**SYDNEY
REGIONAL
DEVELOPMENT
ADVISORY
COMMITTEE**

EXHIBITION OF ENVIRONMENTAL ASSESSMENT FOR NEW CLINICAL SKILLS TRAINING CENTRE AND ALTERATIONS AND ADDITIONS TO EXISTING CANCER THERAPY CENTRE, LIVERPOOL

Below are the Committee's recommendations and the RTA's comments on the subject application:

FIG 8

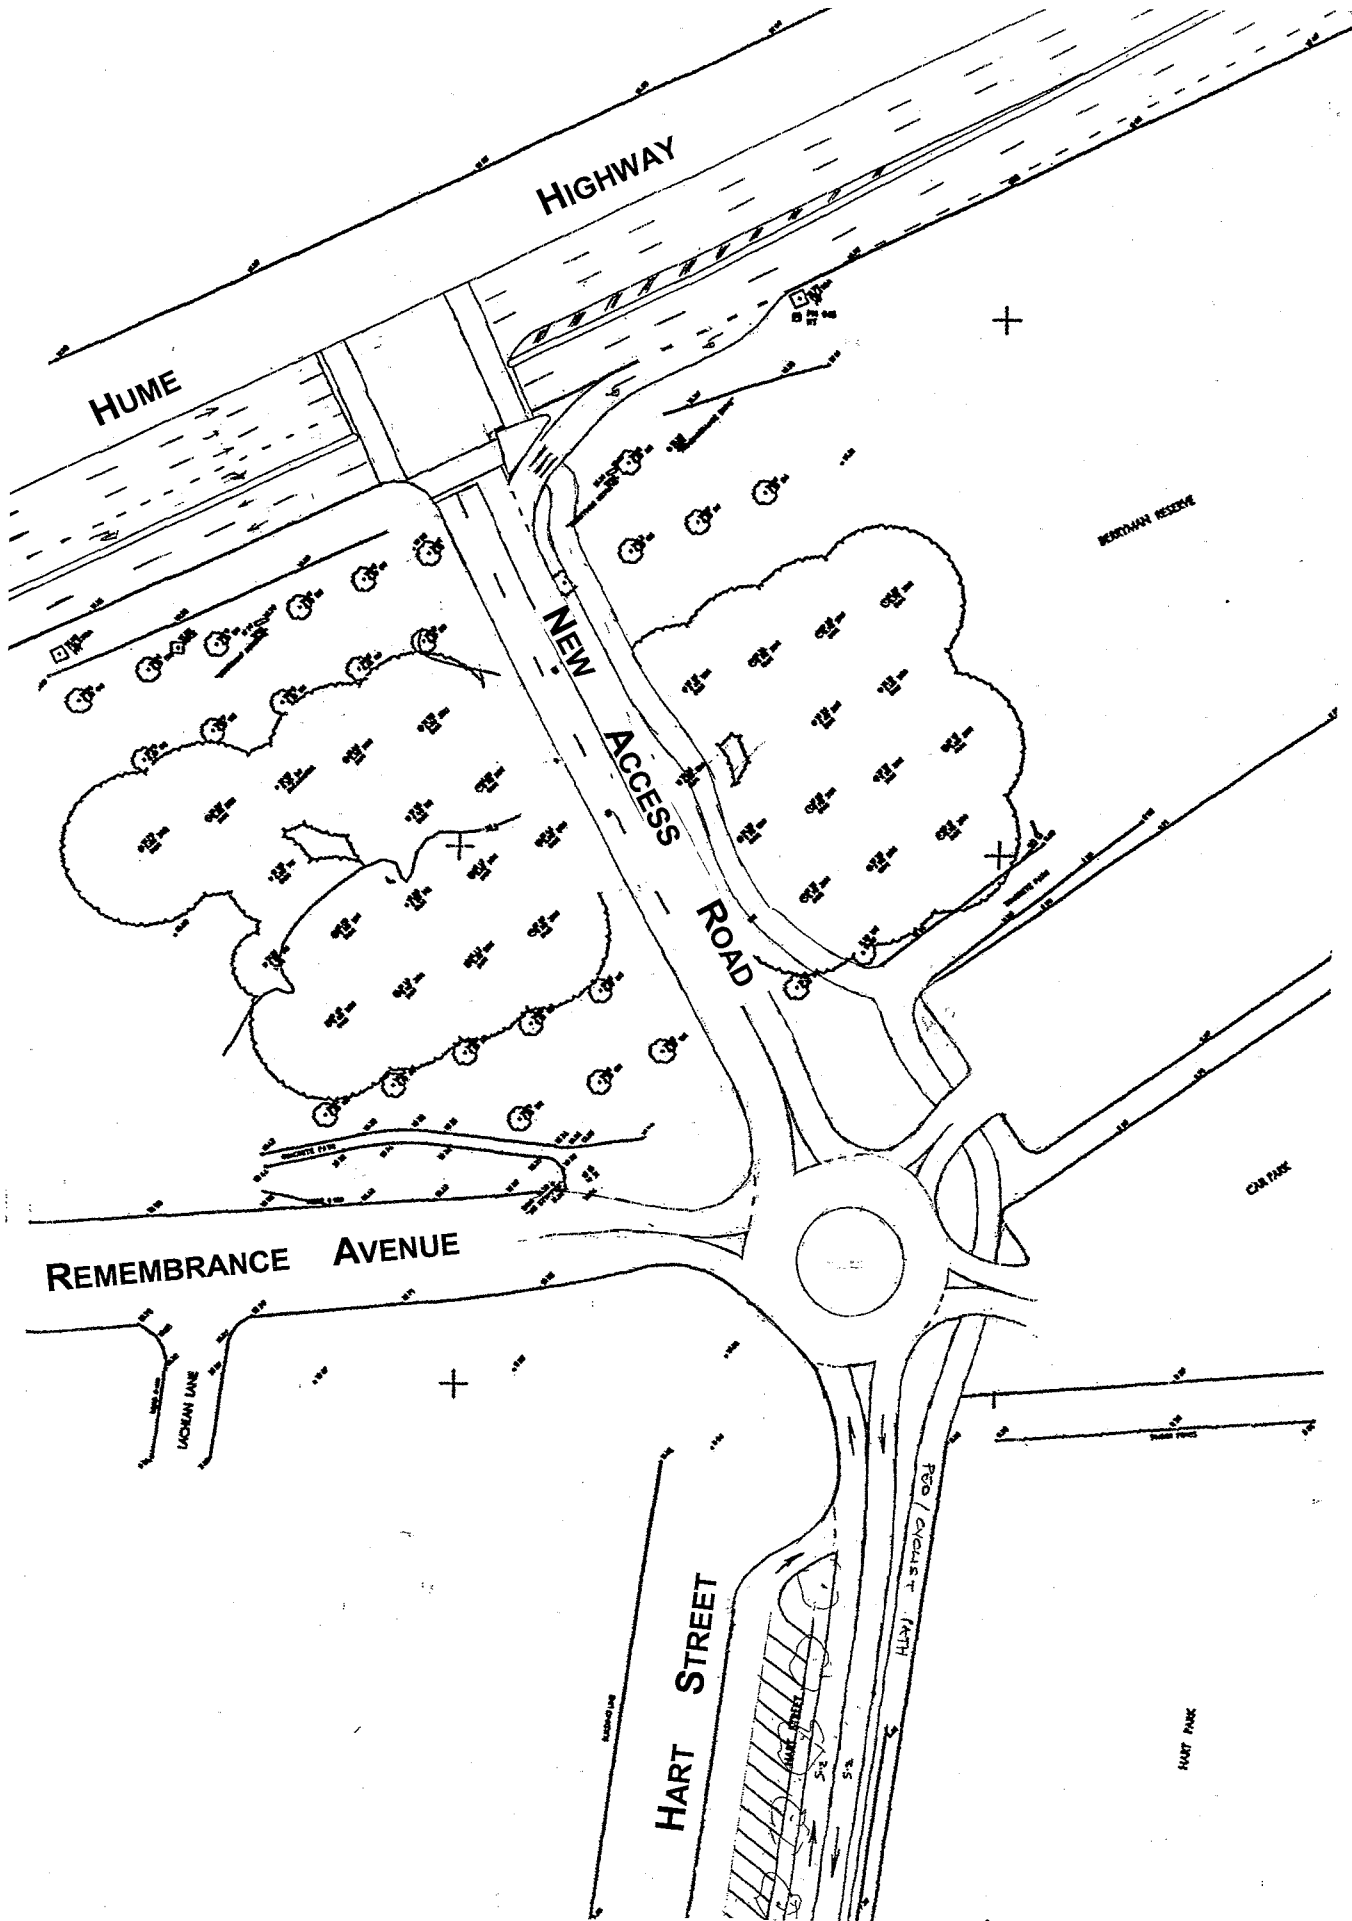
- a) A revised traffic report which reflects the following changes:
 - Cumulative traffic impact of the proposed development and other developments including Liverpool Hospital Redevelopment and the expansion of South West Private Hospital
 - Revised vehicle access without the proposed new access road to Hume Highway
